Application No: R/253/20/HH
Site Address: 33 Knightscroft Avenue Rustington BN16 2HW
Description of works: Single storey annex building ancillary to main dwelling.

Thank you for your internet representation made on 4th January 2021 which has been recorded as an objection with the comments as follows:

PROPOSED PLAN 1:100

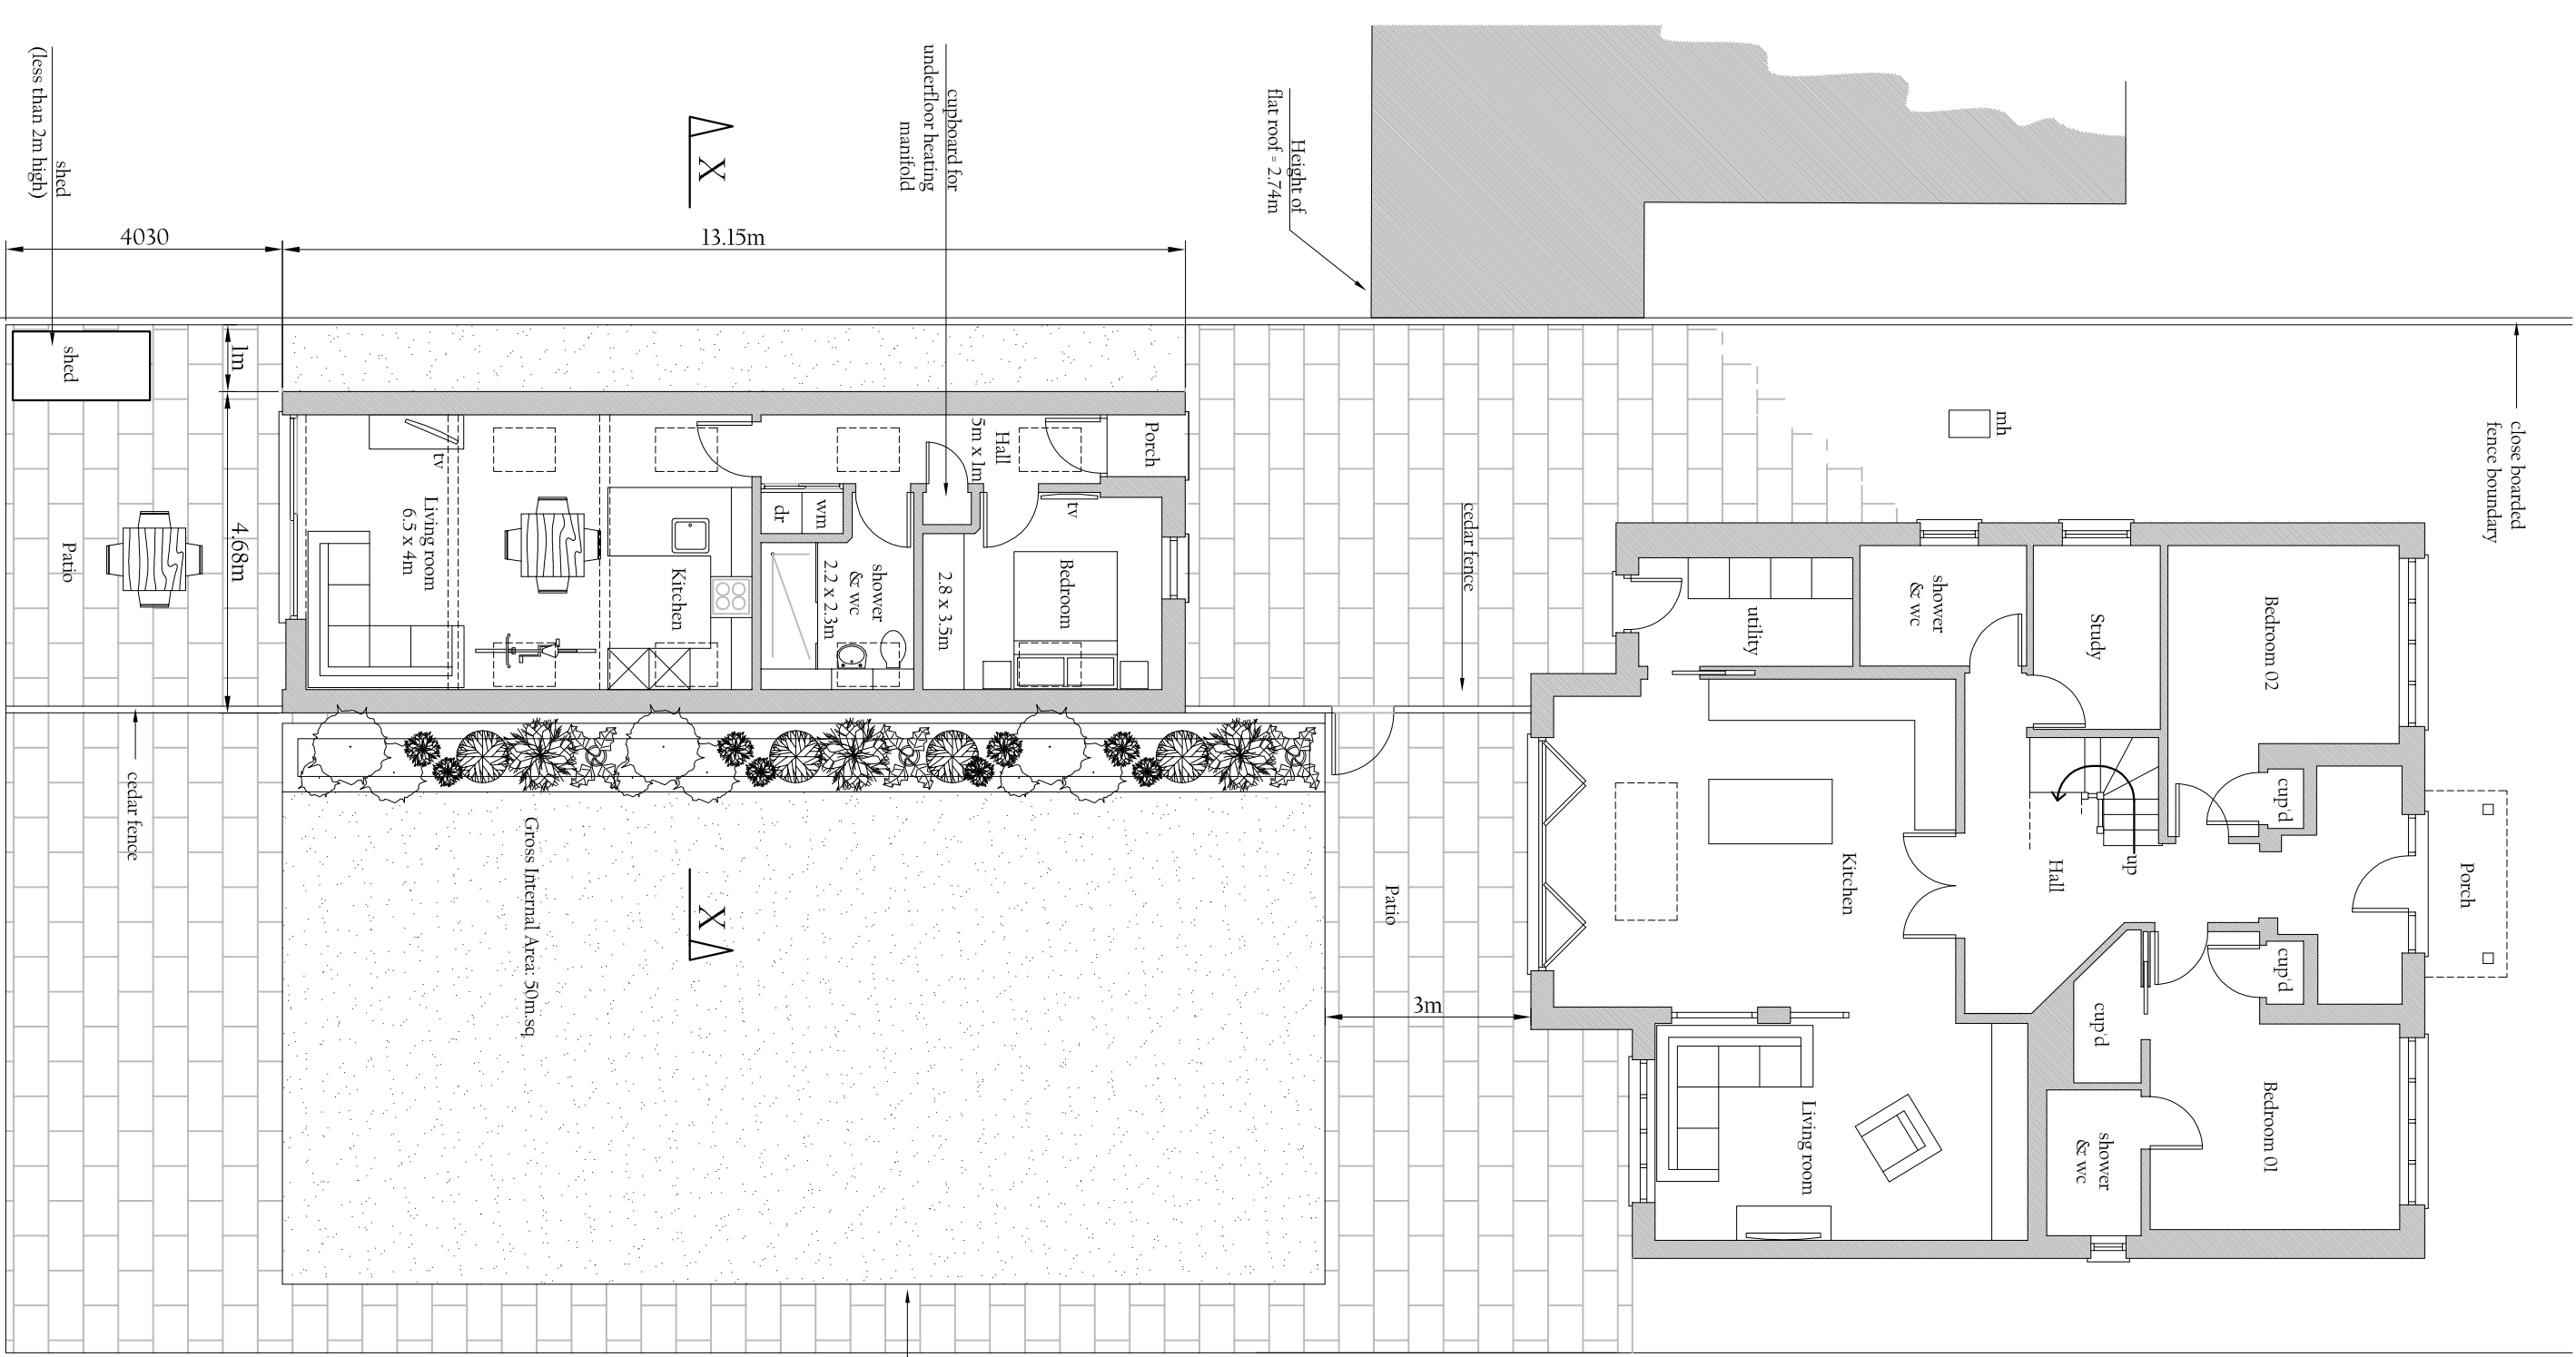
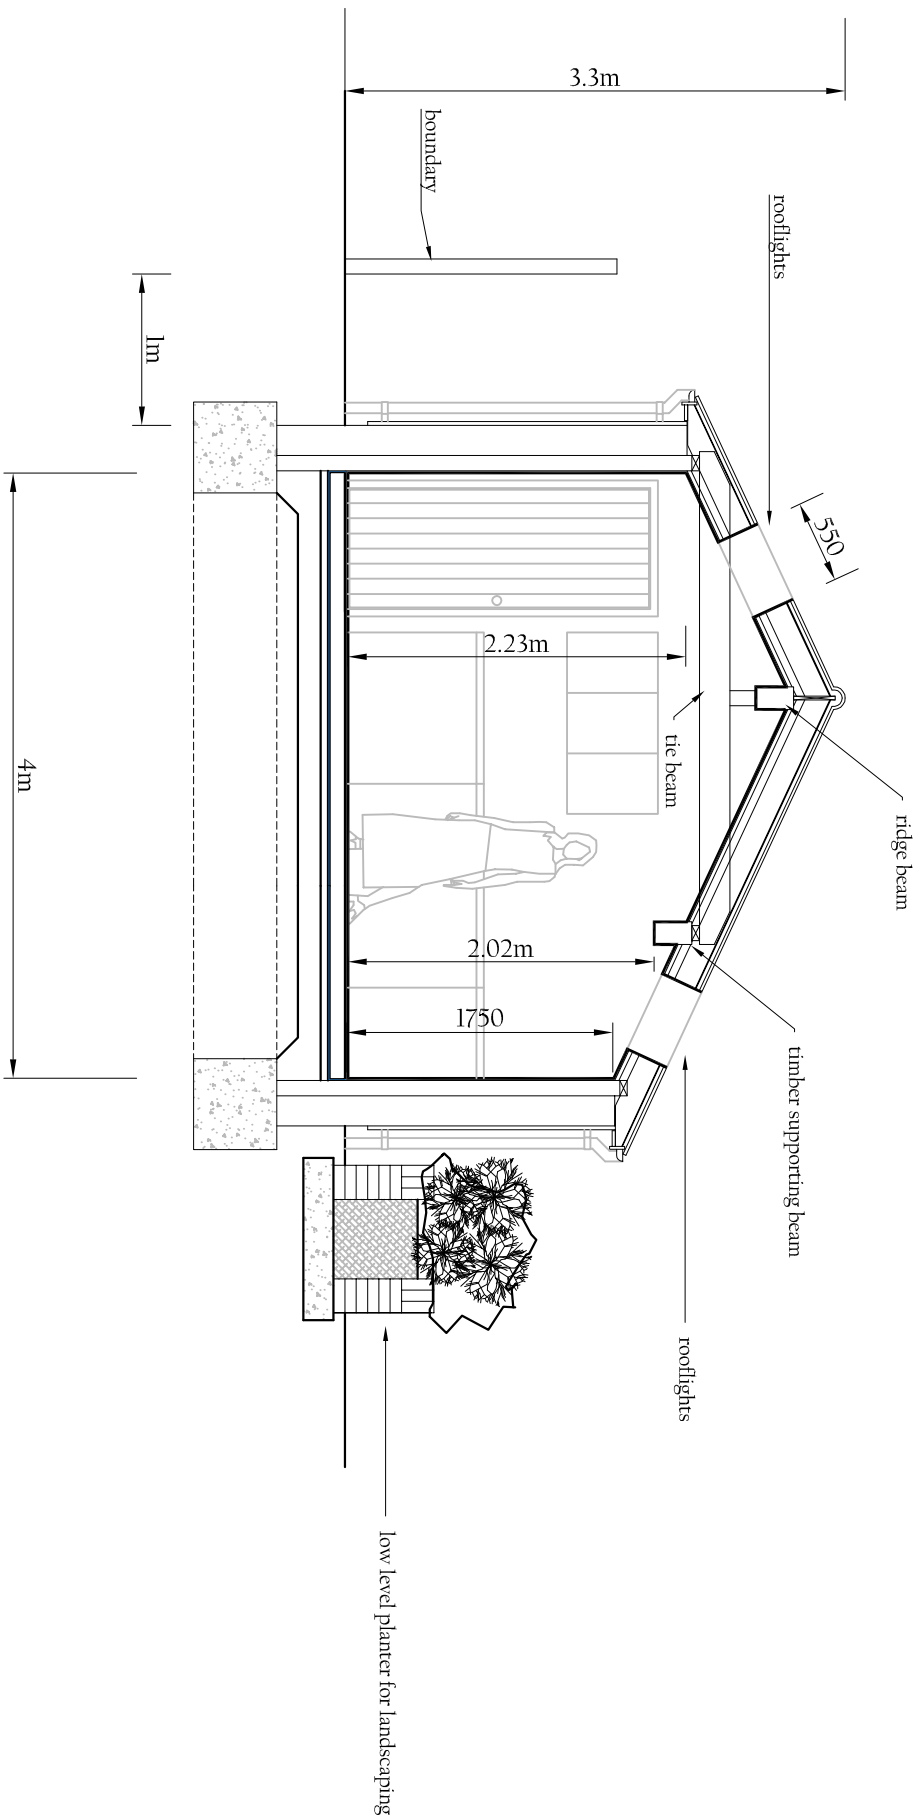
This application is for an individual dwelling within the garden that would be 1 metre away from the boundary with the neighbouring property No.35. The norm on this estate is to have a distance which is equivalent to at least the width of a driveway between any 2 properties. This reduced distance could bring a risk of increased noise and a loss of privacy to No.35 and the size of the proposed building is out of scale with the size of the plot.
